**Modification of Residential Subdivision
Lot 5 DP 788159, The Park Drive, Sanctuary Point**

Please find below Council's detailed submission to the proposed s. 75W modification to approved residential subdivision DA 485-12-2002.

Submission to DA 485-12-2002 MOD 1: 50 Lot Residential Subdivision Nadine St, Sanctuary Point

M:\Projects\20000\26522\Drawings\26522-406-TREES RETAINED.dwg

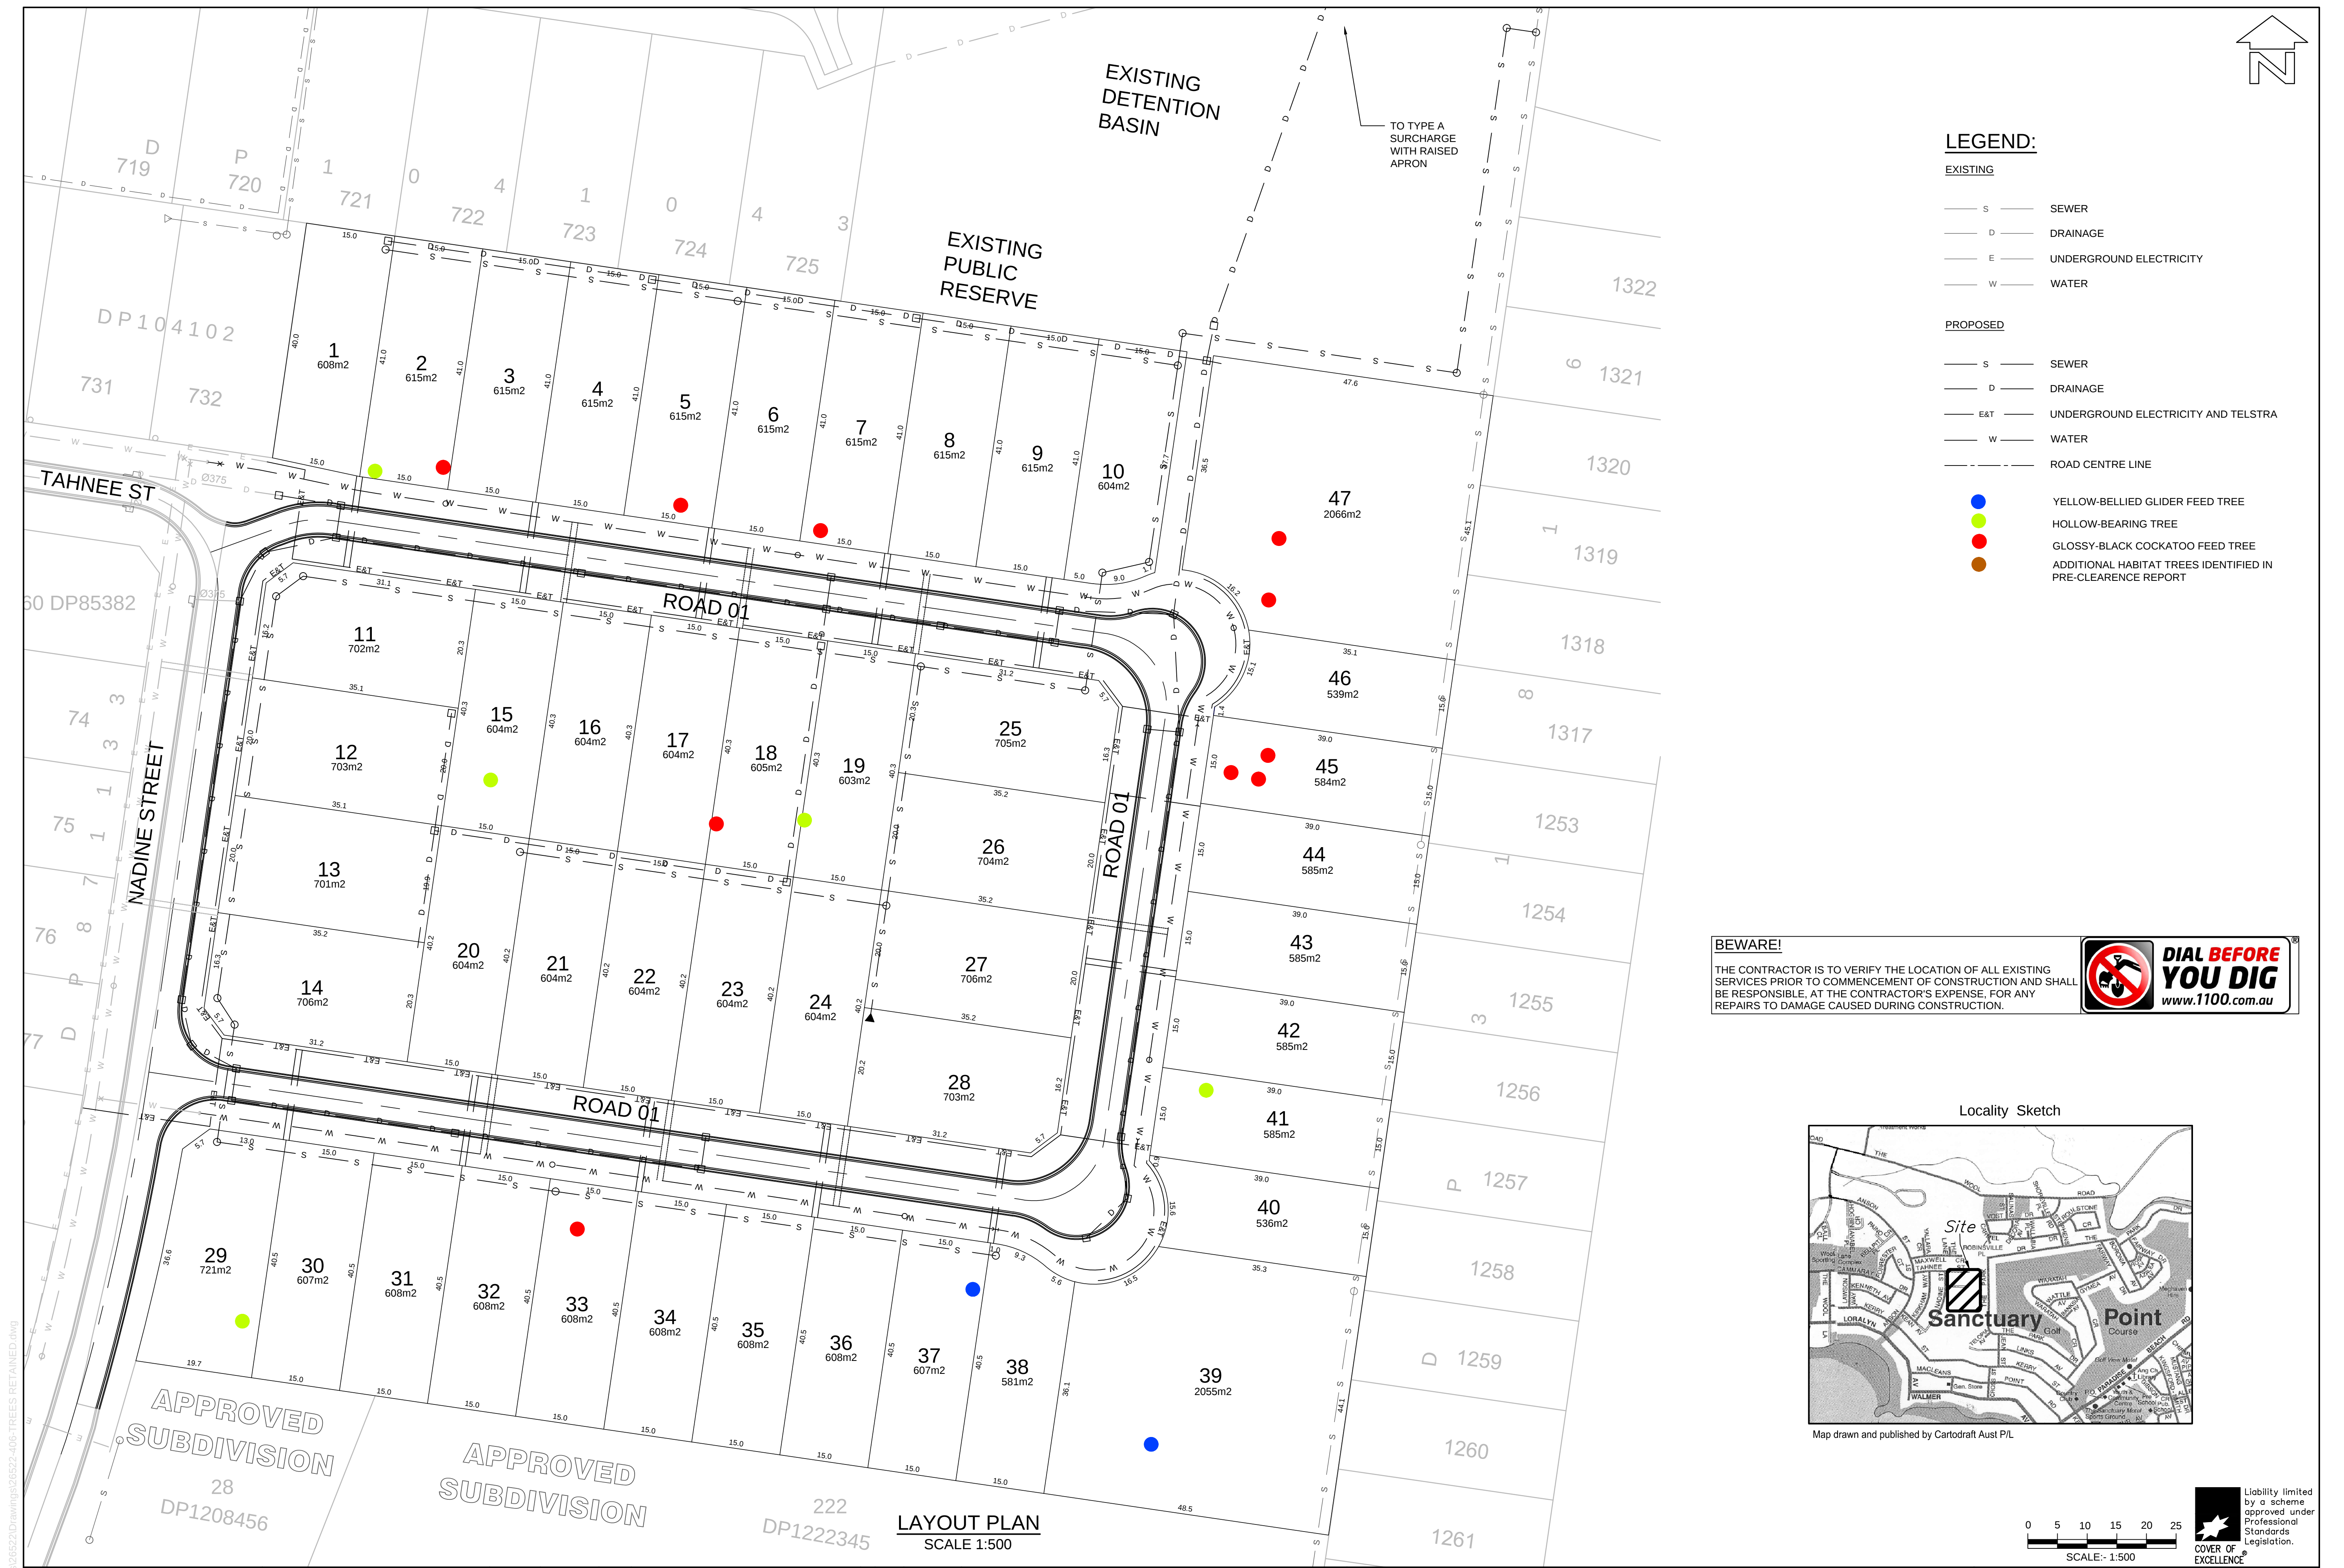
The size and width of lots in the proposed modification provides very limited opportunity to retain any of the trees identified for retention in the vegetation retention plan. Furthermore, Council does not support deferring the cost of development, that is, tree removal, to the future land owner. The current approval and the associated vegetation retention plan relied upon the 'Flora and Fauna Assessment' dated October 2002 by Gunninah Environmental Consultants. Given the significant lapse in time since the initial assessment, i.e. 14 years, removal of vegetation identified in the vegetation retention plan should be subject to a further assessment of significance.
